WATERVIEW EAST PRELIMINARY PLAN

LOCATED IN A PORTION OF SECTION 9, T15S, R65W OF THE 6TH P.M.,
EL PASO COUNTY, STATE OF COLORADO

WATERVIEW EAST PRELIMINARY PLAN		
Designer: BG	Structure Numbers	Project No./Code 181710214
Detailer: PF		
Sheet Subset:		Sheet Number 1 of 9

Project No./Code	181710214
Sheet Number	2 of 9

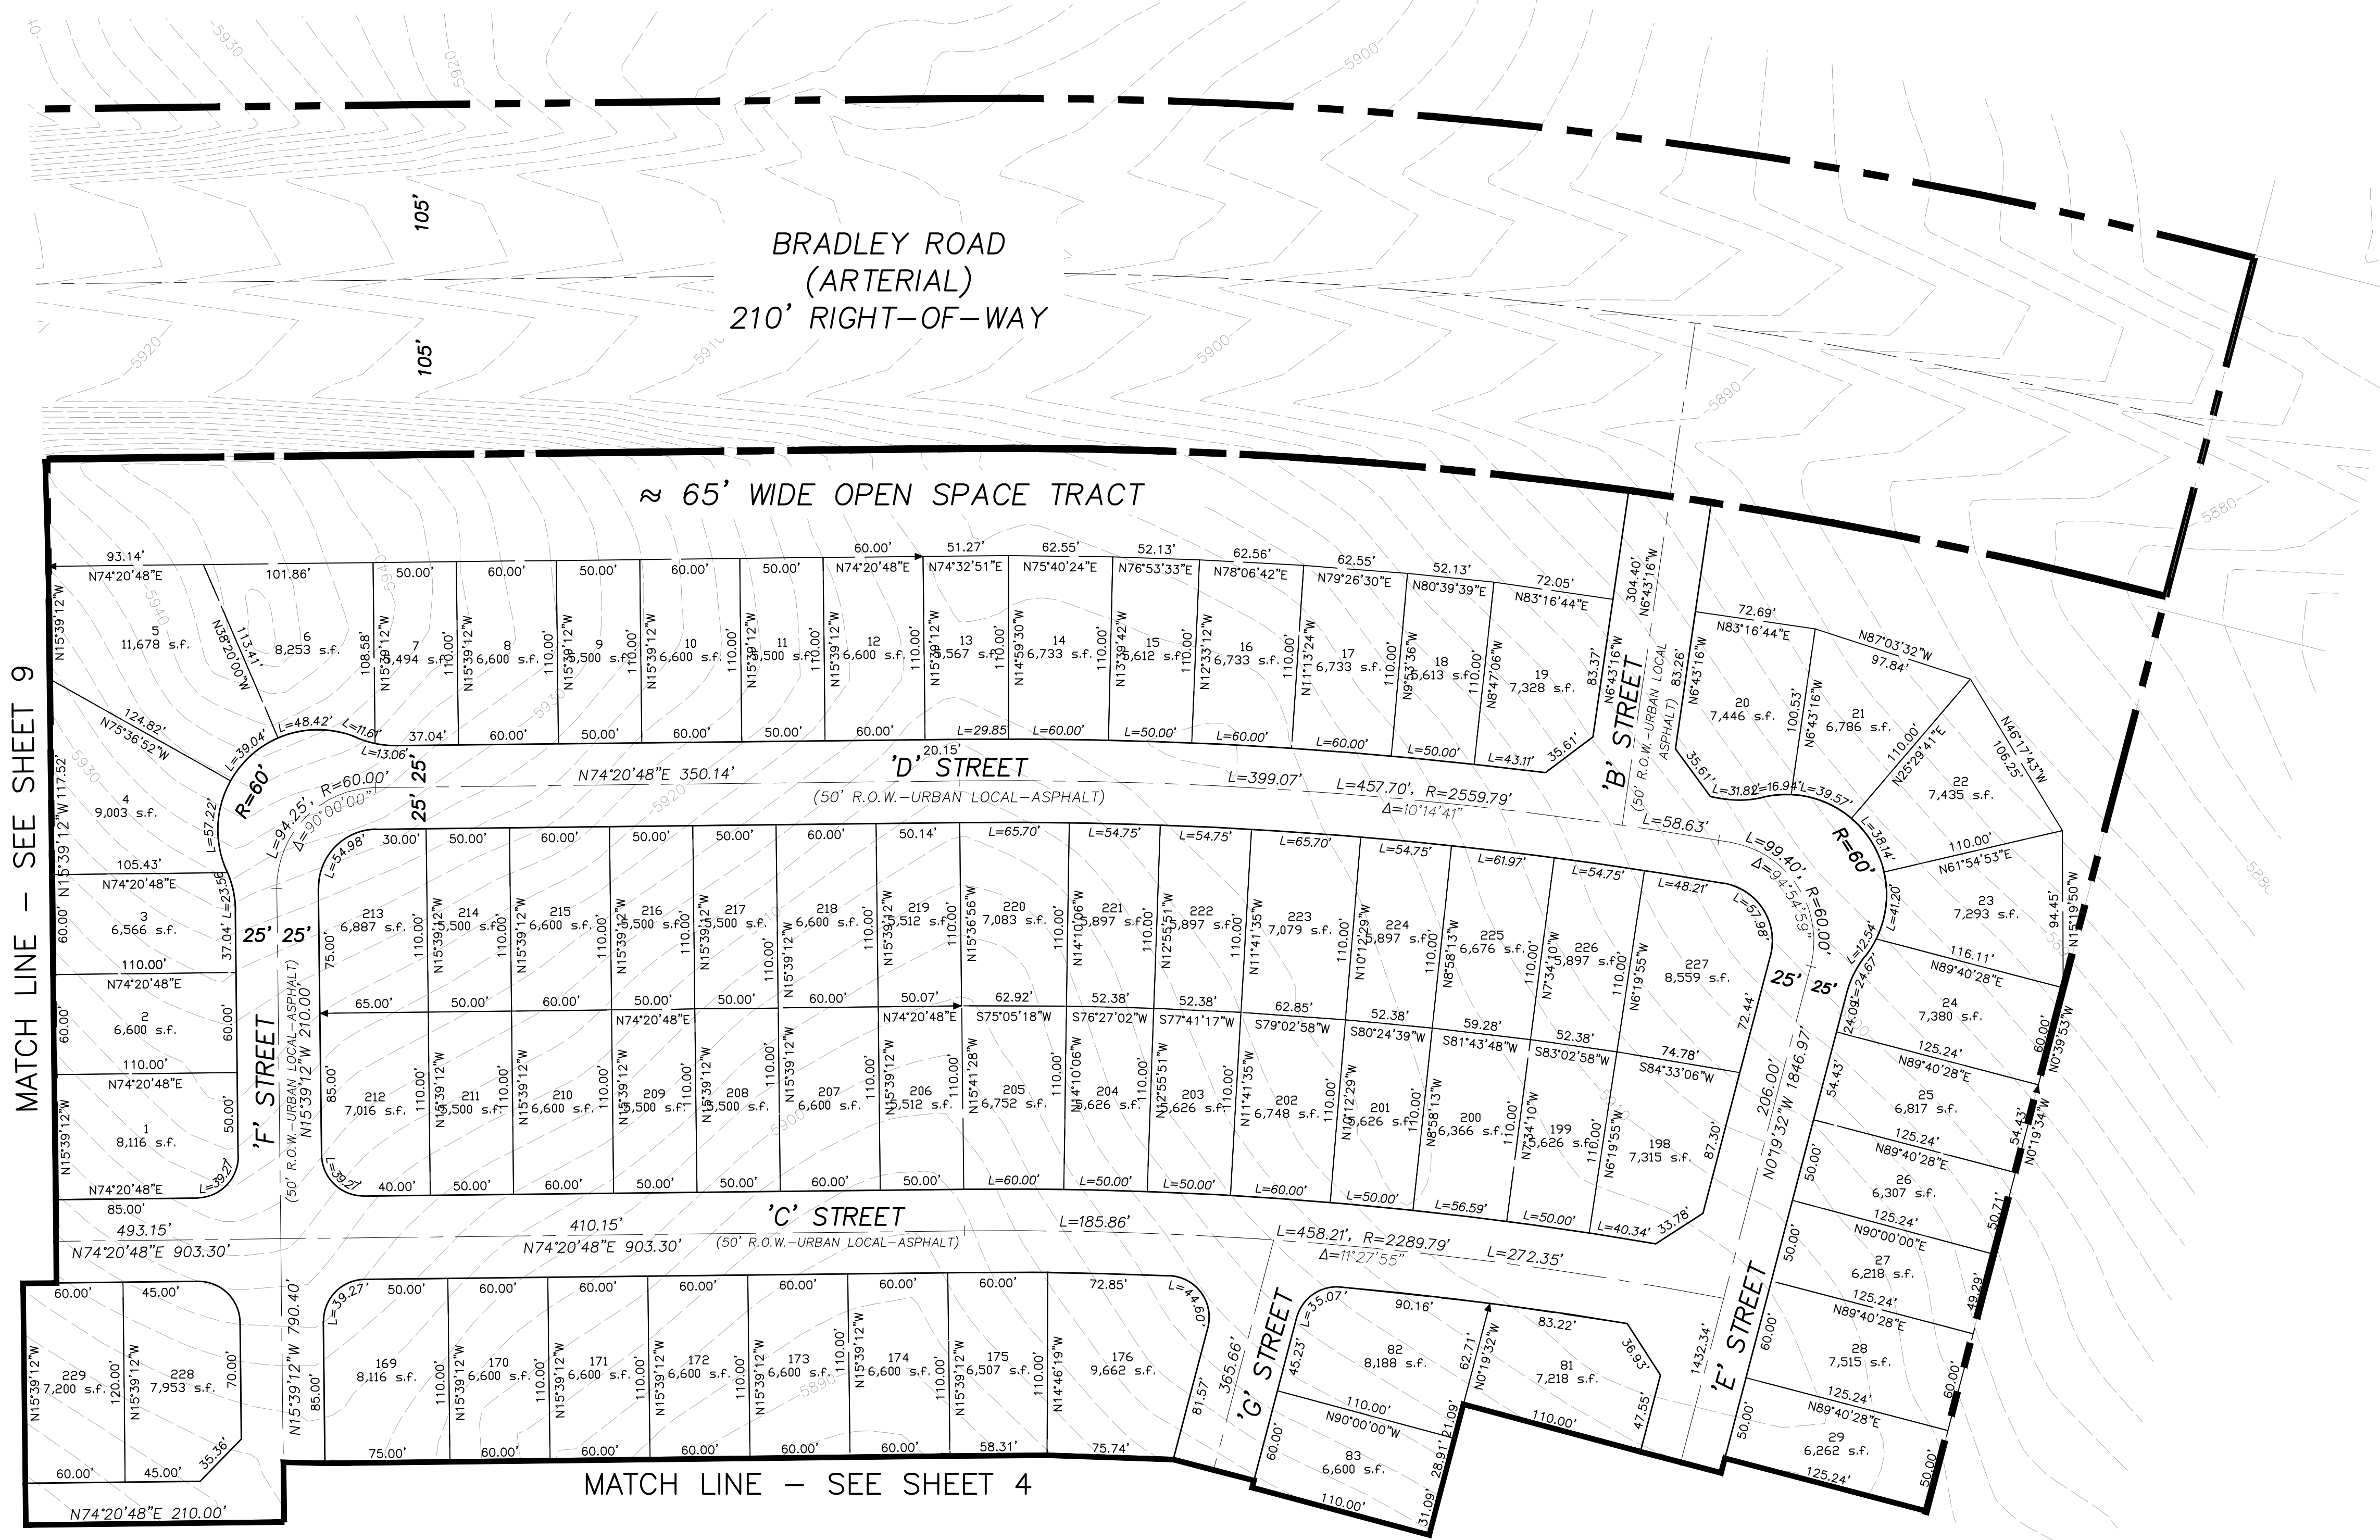
Provide a ROW Stub for a second connection to the property to the east.

Identify as EPC jurisdiction

Identify as within the City of Colorado Springs boundary

Identify as CDOT's jurisdiction

Show the proposed off-site improvements

Add a key map on sheet 3 to 9

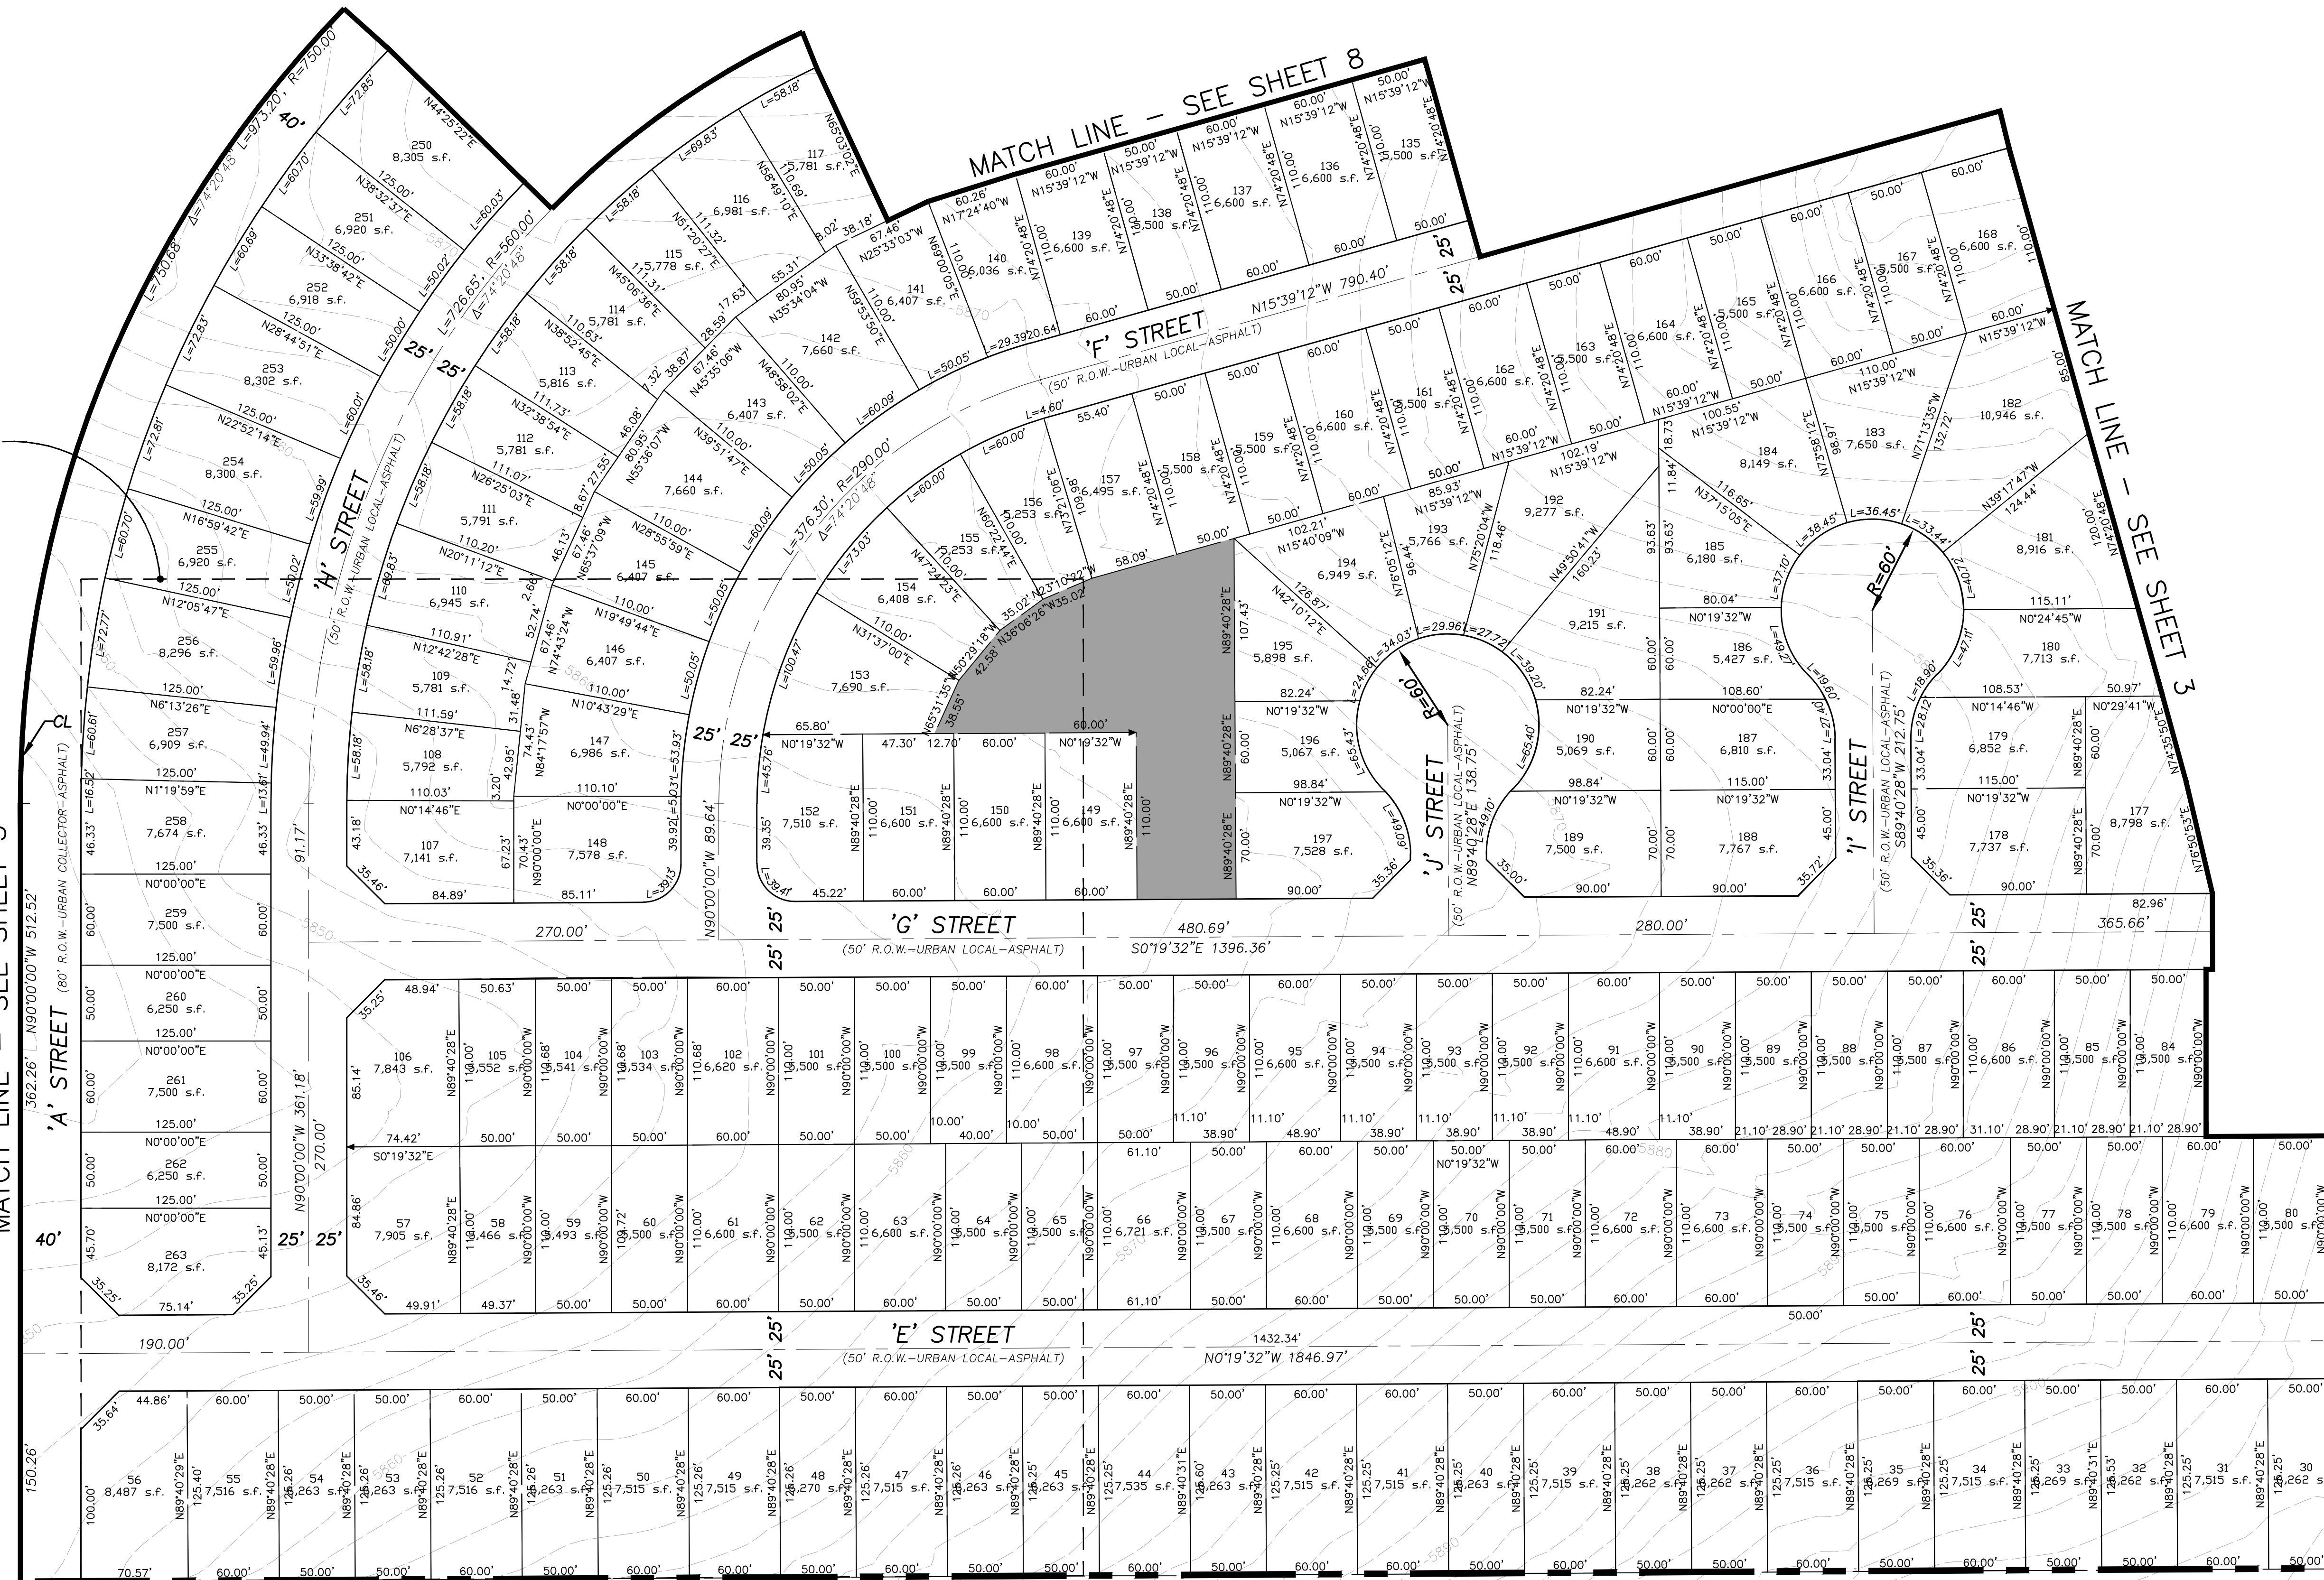
Add a key map on sheet 3 to 9

Does not appear to meet intersection spacing criteria

Show the roadway geometry (on and off site)

Sheet Number 4 of 9

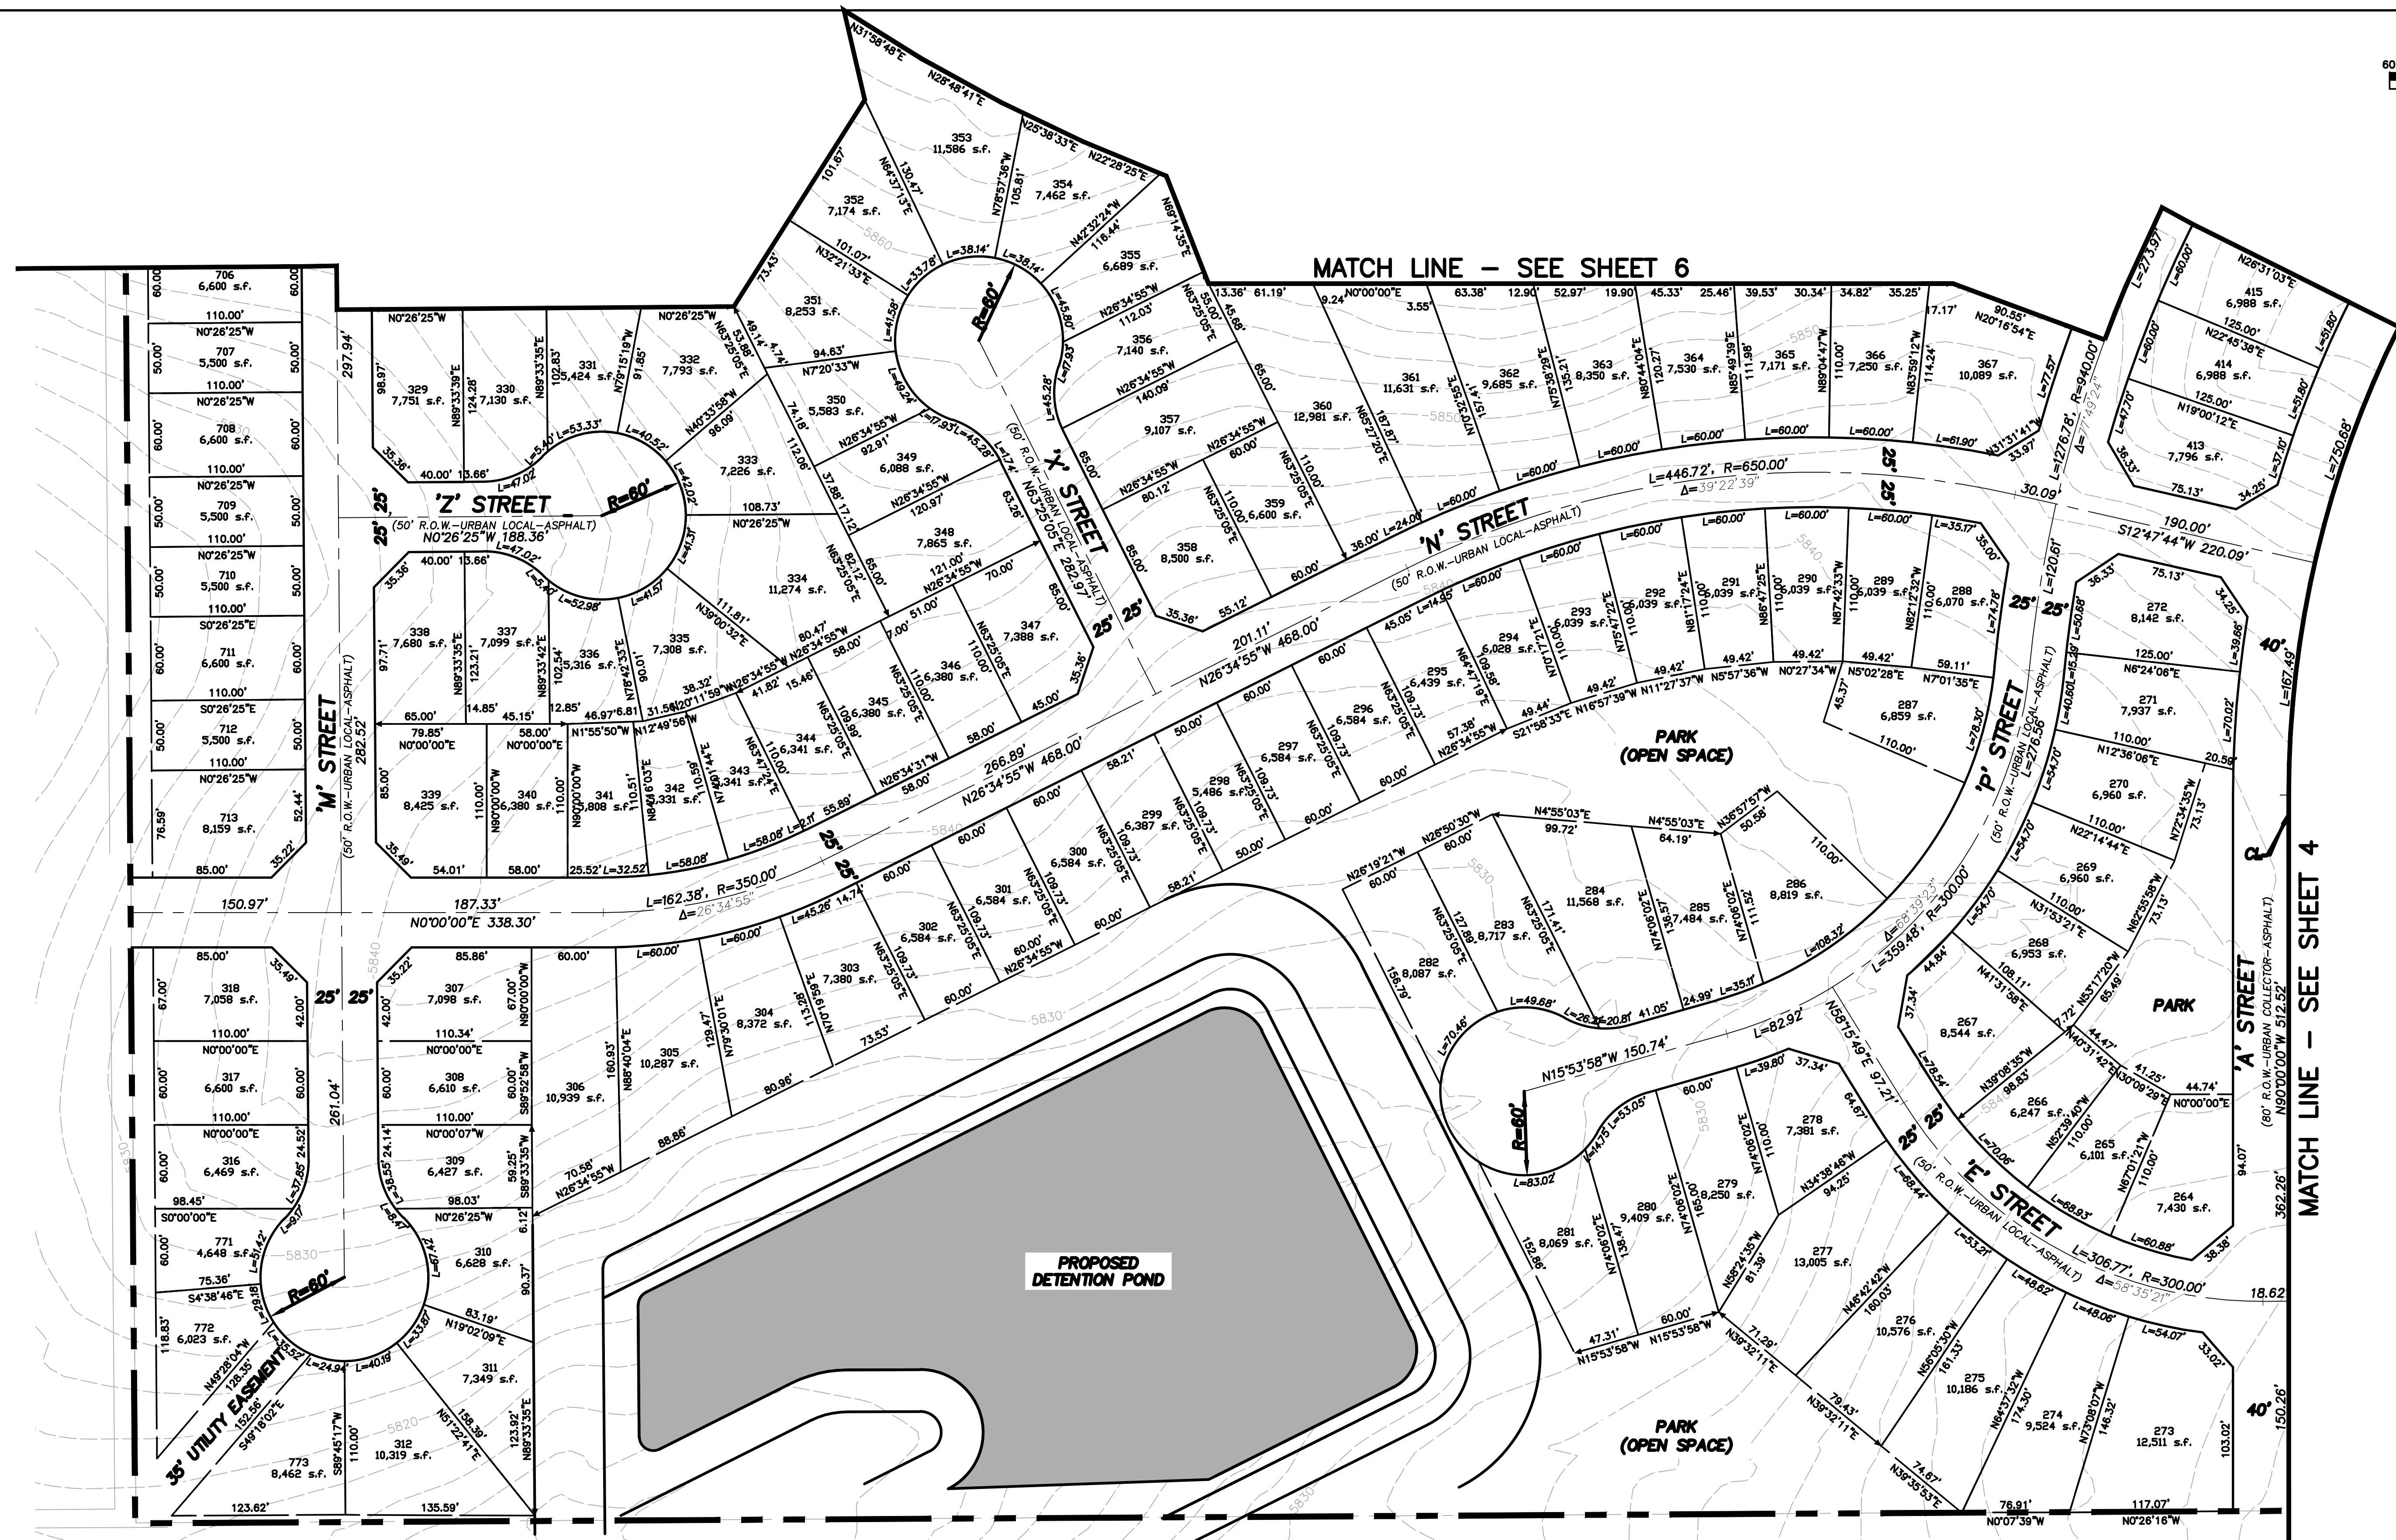
Revise label to "Urban Non-Residential Collector"

Please label. What is the purpose?

If your intent is plat these lots, do not show potential school site. You need to decide at this stage if the lots will be platted, or if they will become a school.
